WELWYN HATFIELD BOROUGH COUNCIL – DEVELOPMENT MANAGEMENT
DELEGATED REPORT

APPLICATION No: N6/2013/2219/FP

SITE ADDRESS: 7 Densley Close, Welwyn Garden City

DESCRIPTION OF DEVELOPMENT: Erection of single storey front, side and rear extension and alterations to roof

Drawing Title: PROPOSED PLANS AND ELEVATIONS

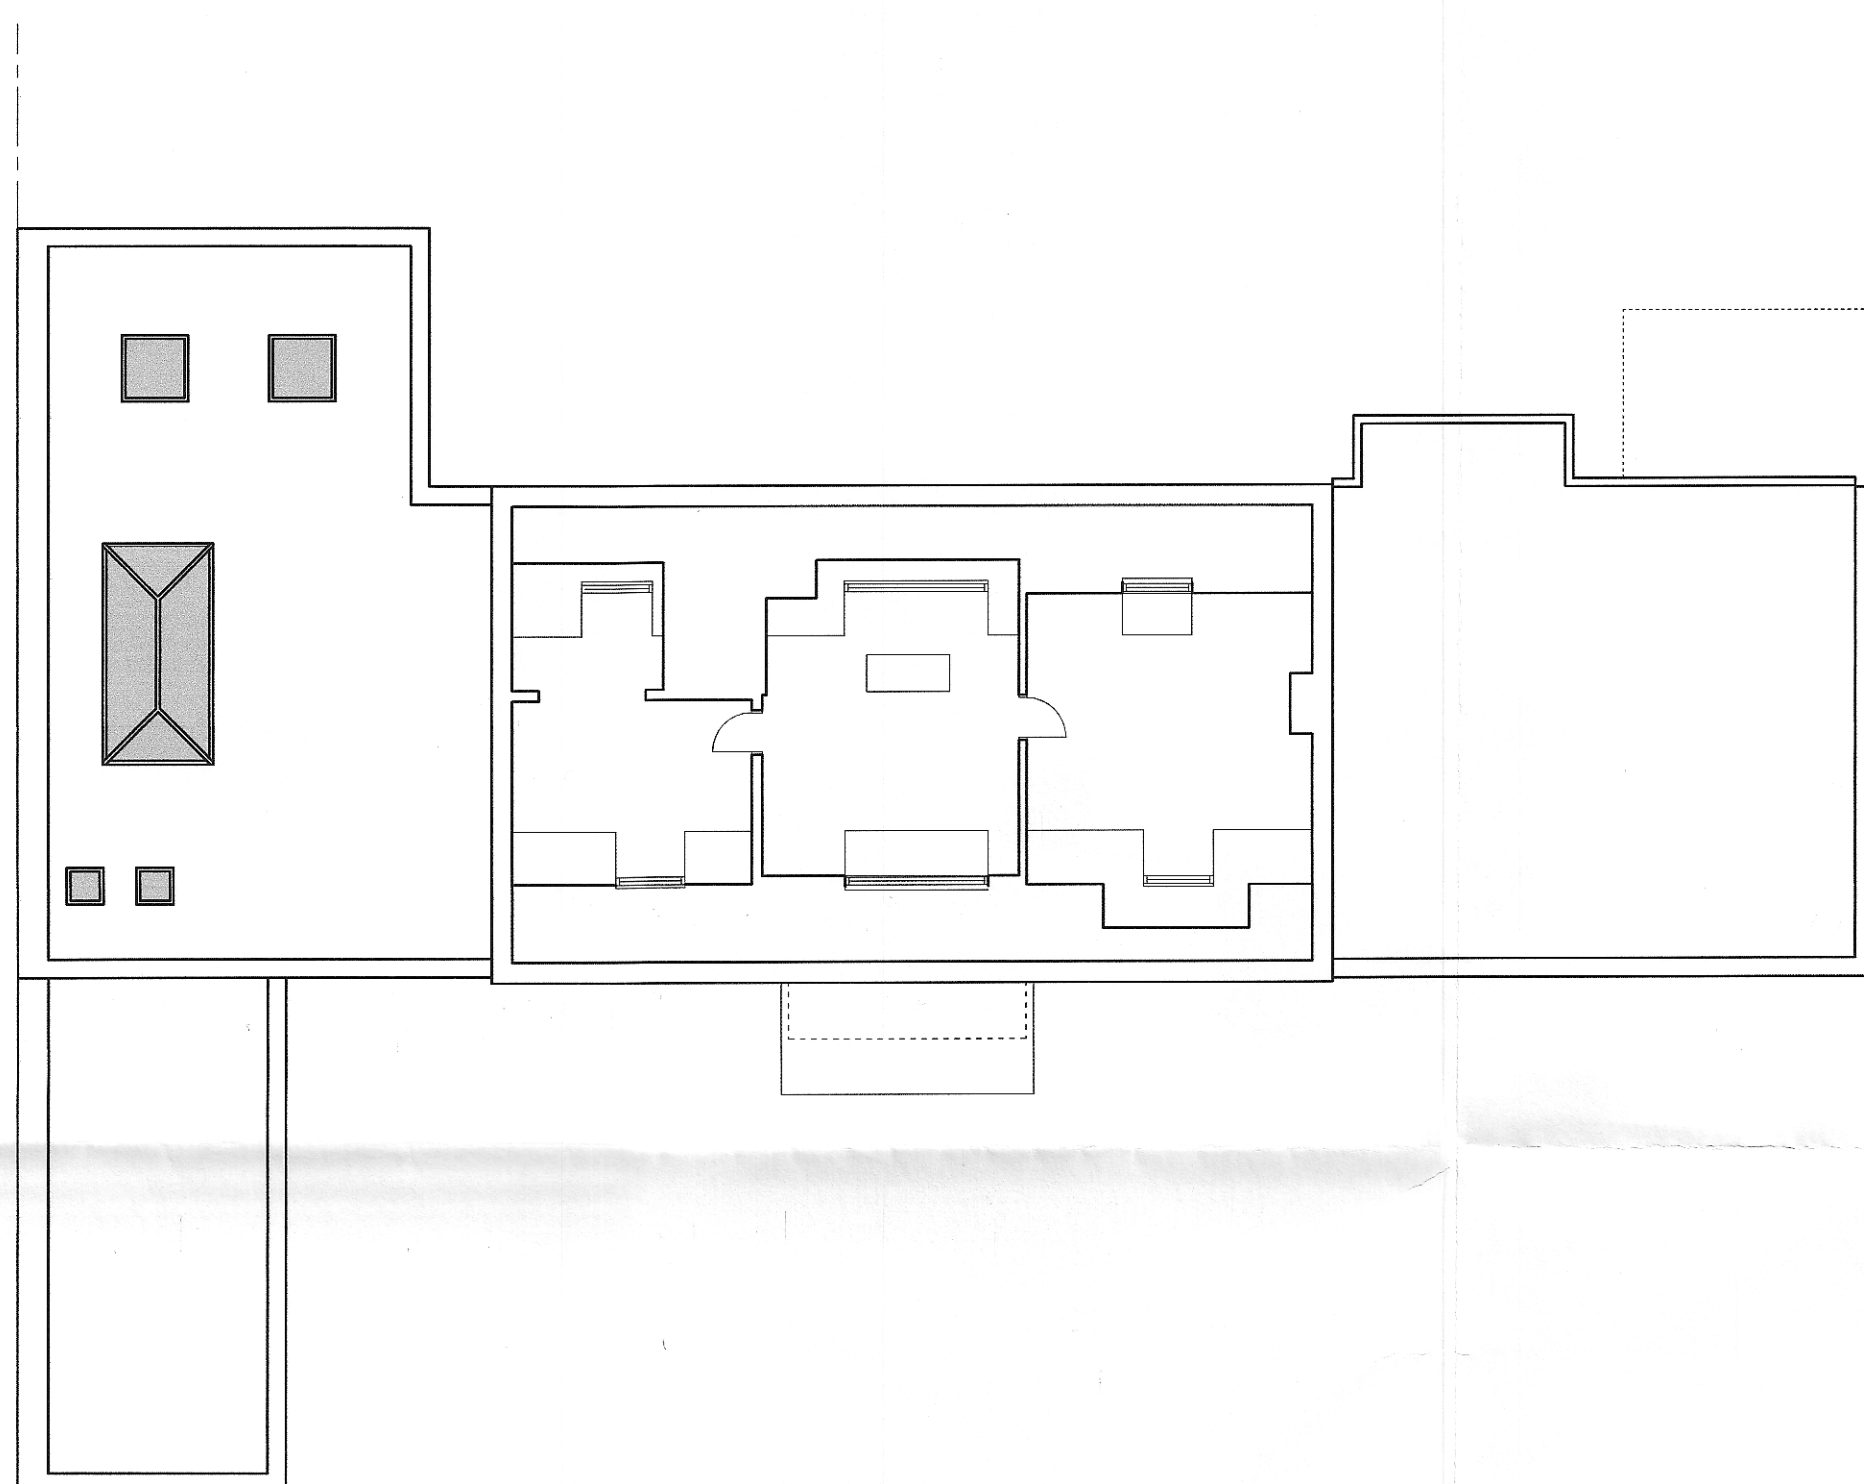
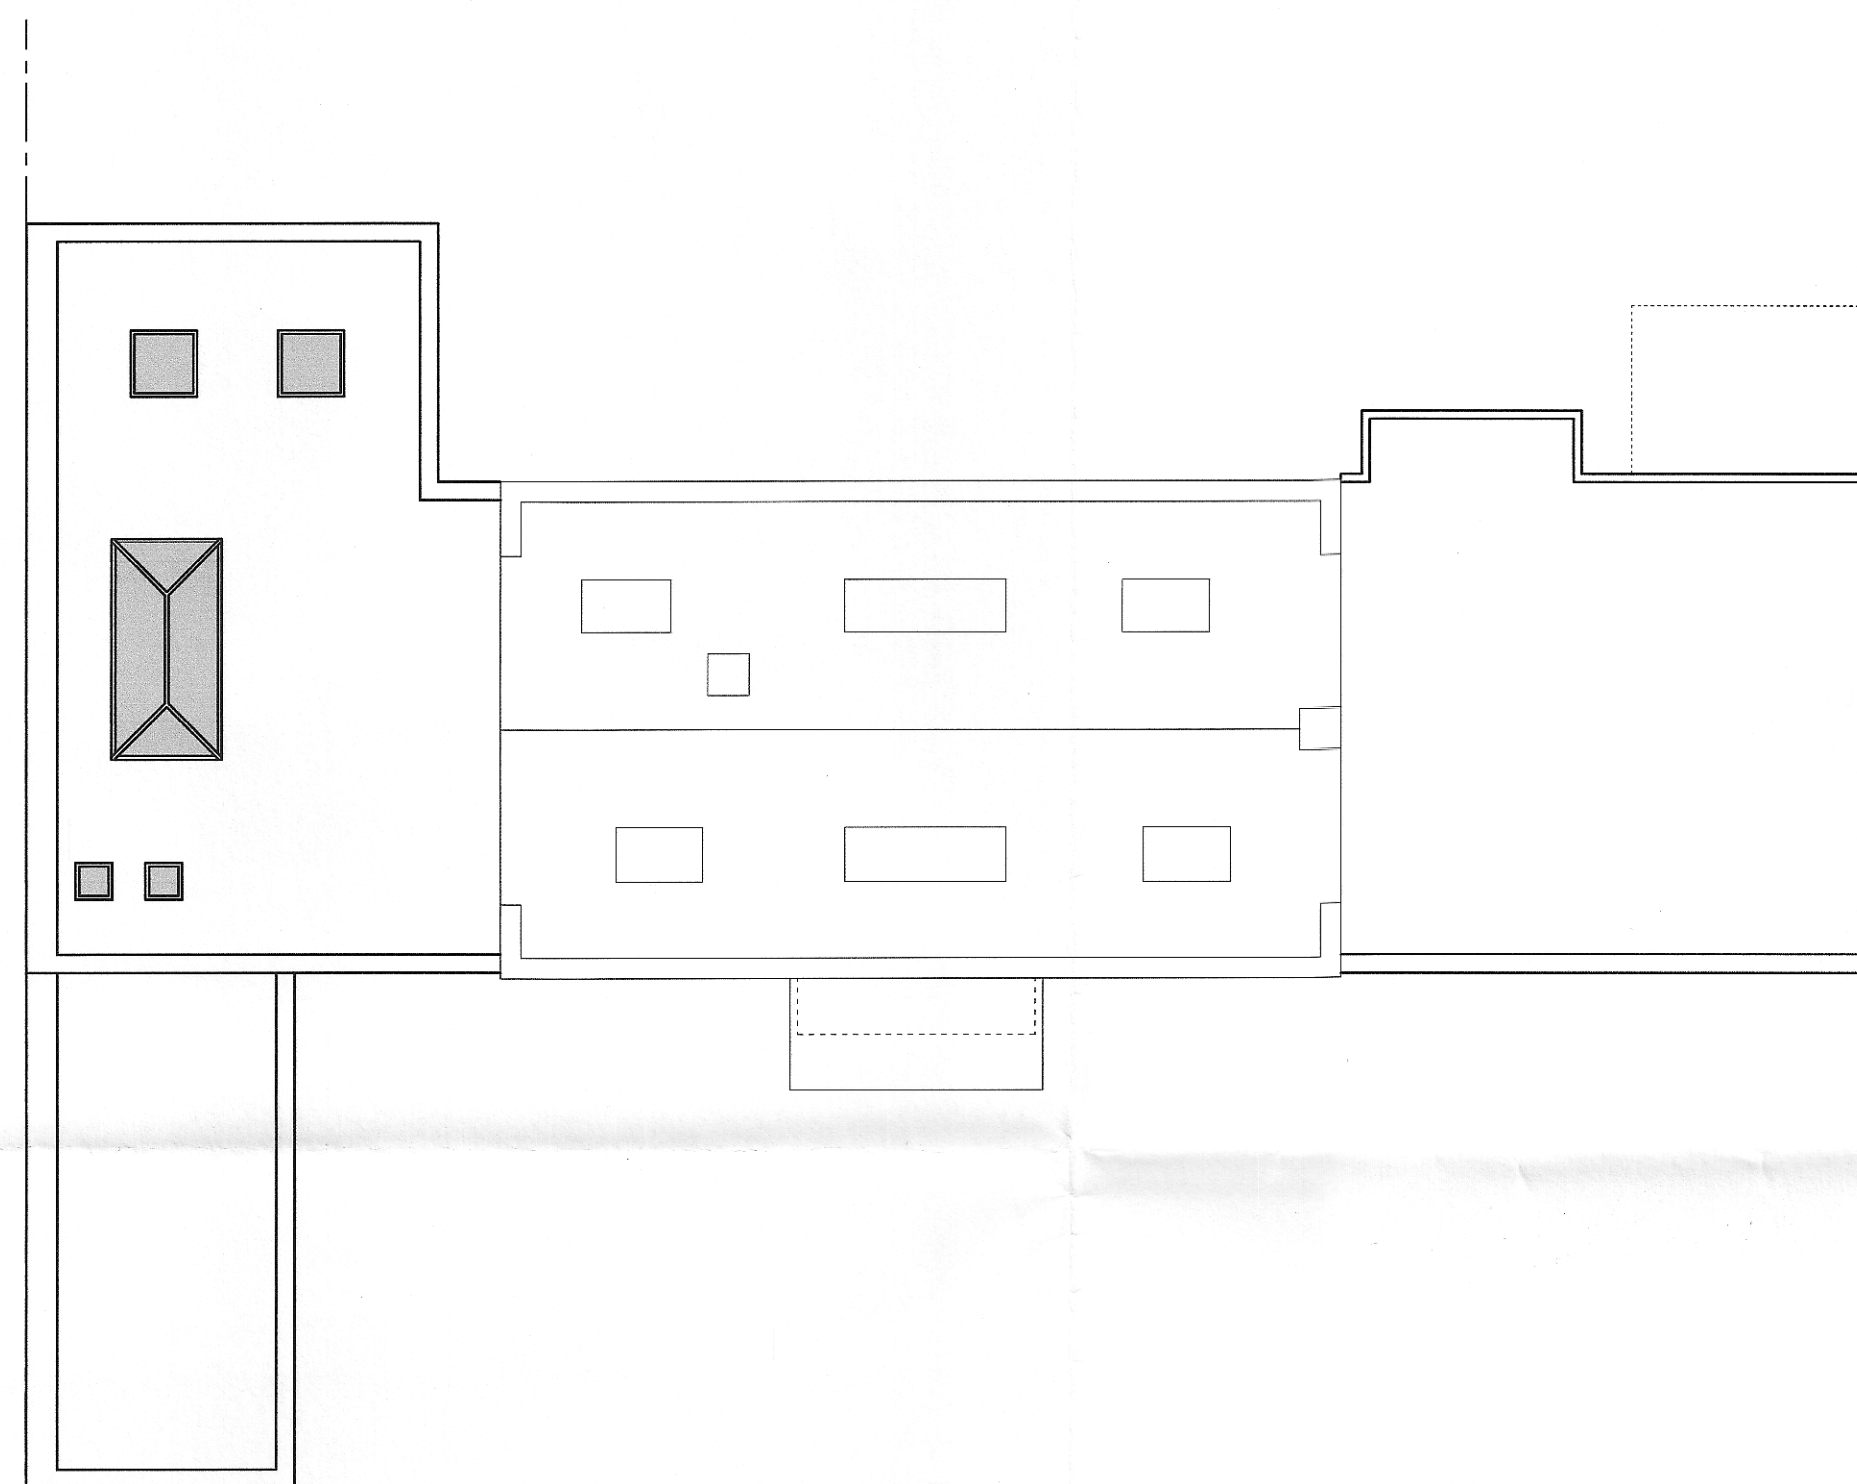
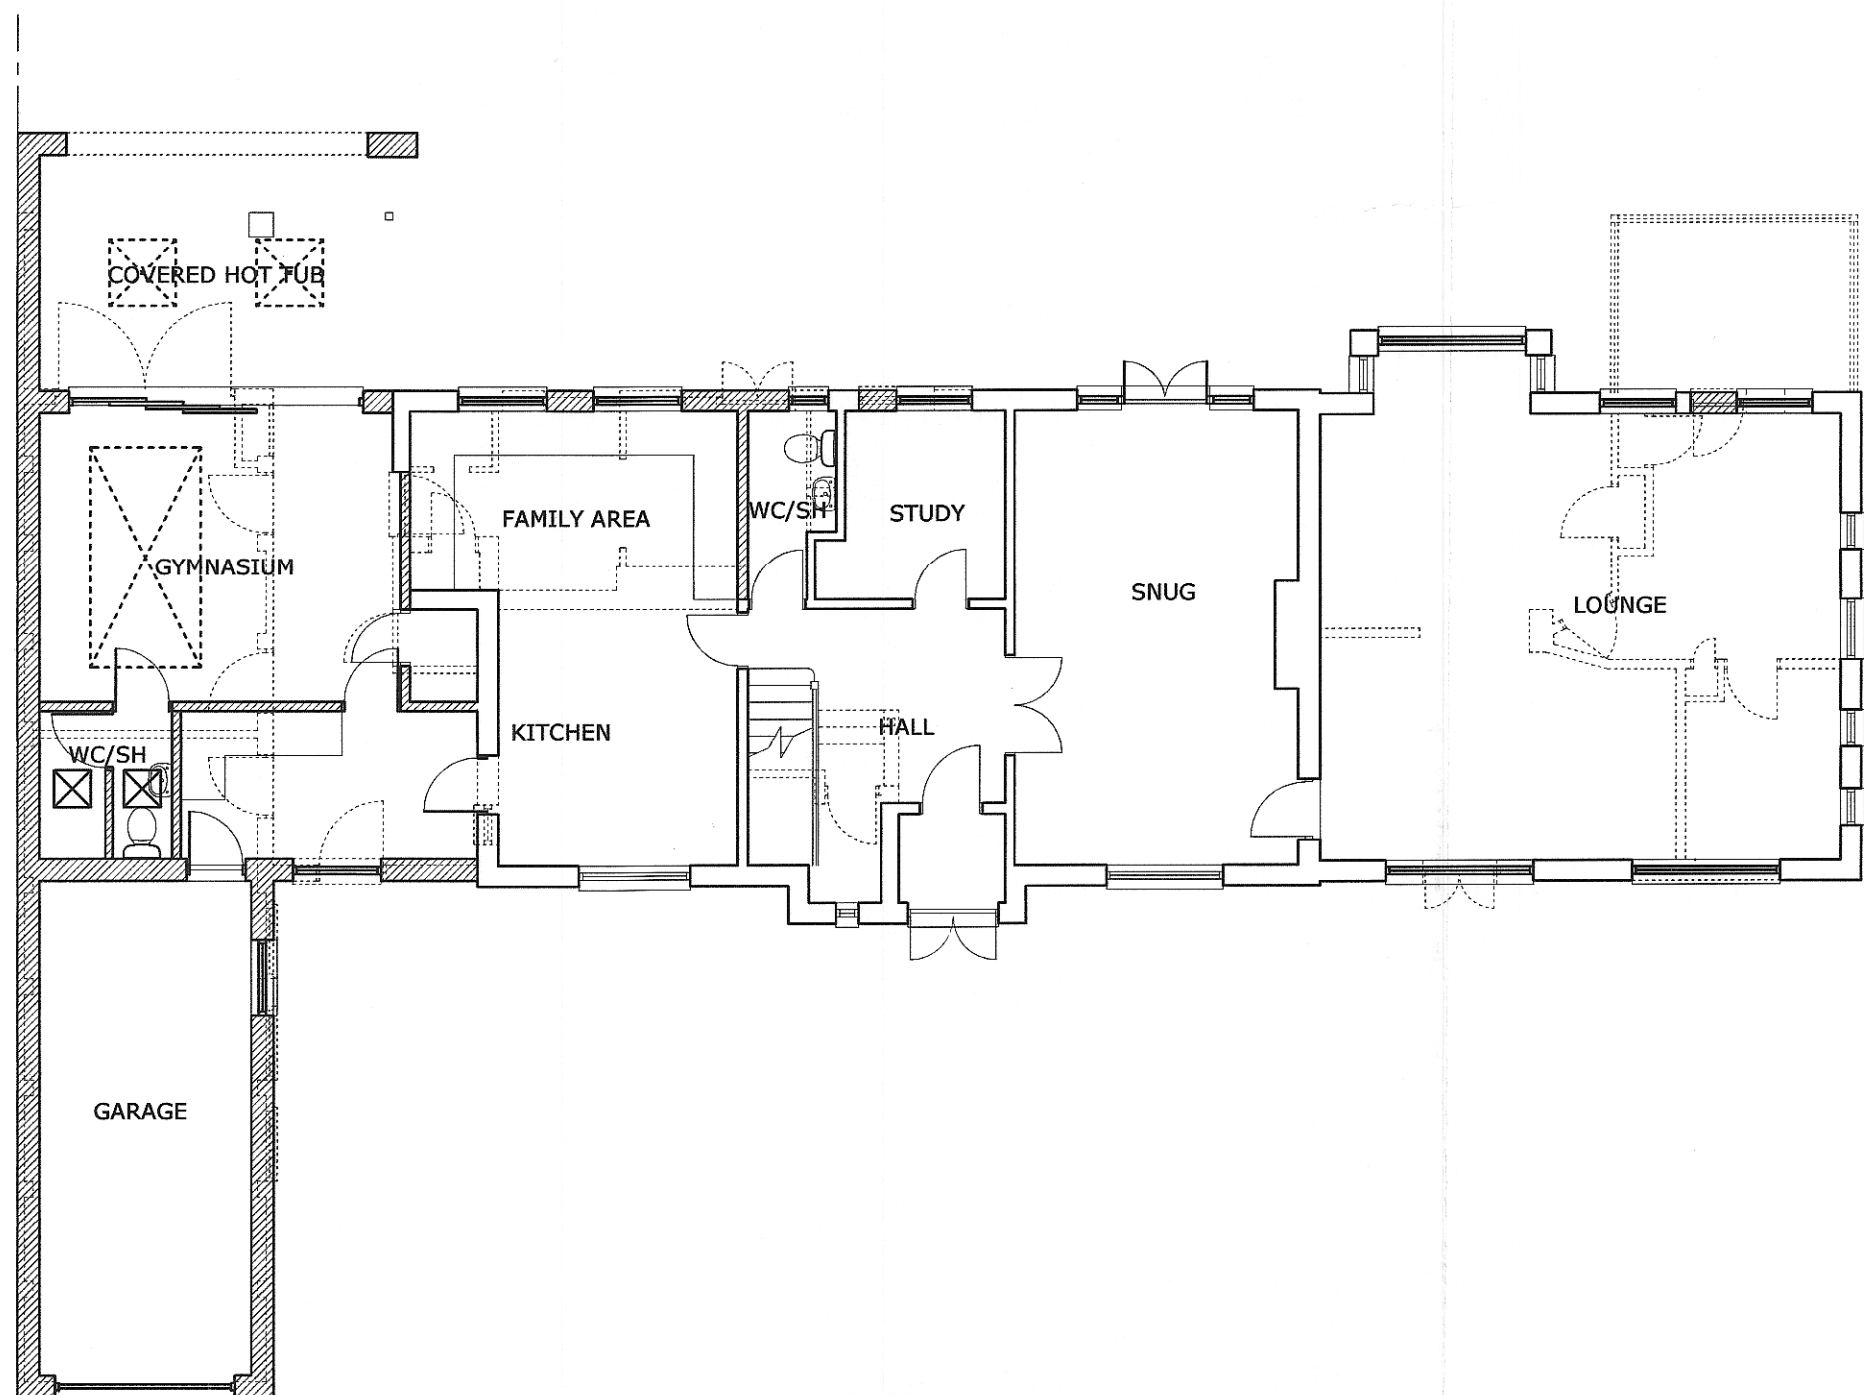
The proposal seeks to replace the existing single storey side extension along the northern elevation with a single storey side extension increasing the height of the extension to a maximum 3.25m and increasing the depth at the rear by a further 1m. Furthermore, the existing single storey extension attached to the southern elevation will increase in height by a further 0.2m. The proposal differs from that previously refused under planning application, ref: N6/2013/1278/FP, by virtue of the northern elevation extension being reduced in height by 0.35m and the southern elevation extension being reduced in height by approximately 0.35m. The proposal was refused by virtue of the height of the parapet wall being near to the height of the first floor window sills which would appear stark and over dominant within the streetscene.

It is considered that the proposal has been sufficiently reduced in height to reduce the overall bulk and would more in keeping with the height of the parapet walls which exist within the streetscene. Furthermore, the proposal would incorporate coping stone as the parapet finish. The rooflights proposed on the northern side extension will not be visible within the streetscene and has been confirmed through an email from the agent, dated 10 December 2013. It would also be appropriate for condition the application for samples of materials to be submitted prior to commencement of development to ensure the materials appropriately match the existing dwellinghouse.

The properties most impacted by the proposal are neighbouring properties, No. 5 Densley Close to the north and No.19 Scholars Mews to the south. The existing garage is attached to the neighbouring single storey side extension at No.5 Densley Close. The existing garage already extends further beyond the rear of No.5 by approximately 1m with the proposed replacement side extension resulting in approximately 2m extension beyond the rear of No.5. Windows exist on the rear of No.5 in close proximity to the proposed extension however a 2m extension is not considered to result in an unduly dominant feature when viewed from these windows. Furthermore, the proposal is not considered to detrimentally impact upon loss of sunlight/daylight skylight when compared to the existing extension taking into consideration the extension will only extend a further 1m in depth and the orientation of No.5 to the north east of the application dwelling where a limited amount of light reaches these windows during large parts of the day.

The proposed height increase of 0.2m to the existing single storey side extension extending beyond the southern elevation is considered sufficient distance from No.19 Scholars Mews (approximately 10m) not to detrimentally impact upon loss of sunlight/daylight. The existing side windows are being retained with the floor level increase internally of approximately 15cm. However, the existing window openings and siting are not being altered and therefore the proposal is not considered to result in any further overlooking/loss of privacy to neighbouring properties when compared with the existing situation. The proposal is therefore considered in accordance with policy D1 of the Welwyn Hatfield District Plan, 2005.

2. C.13.1 Development in accordance with approved plans/details: 3081-OS1 & 3018-OS2 Rev A received and dated 24 October 2013 & 3018-P01 Rev C received and dated 11 December 2013
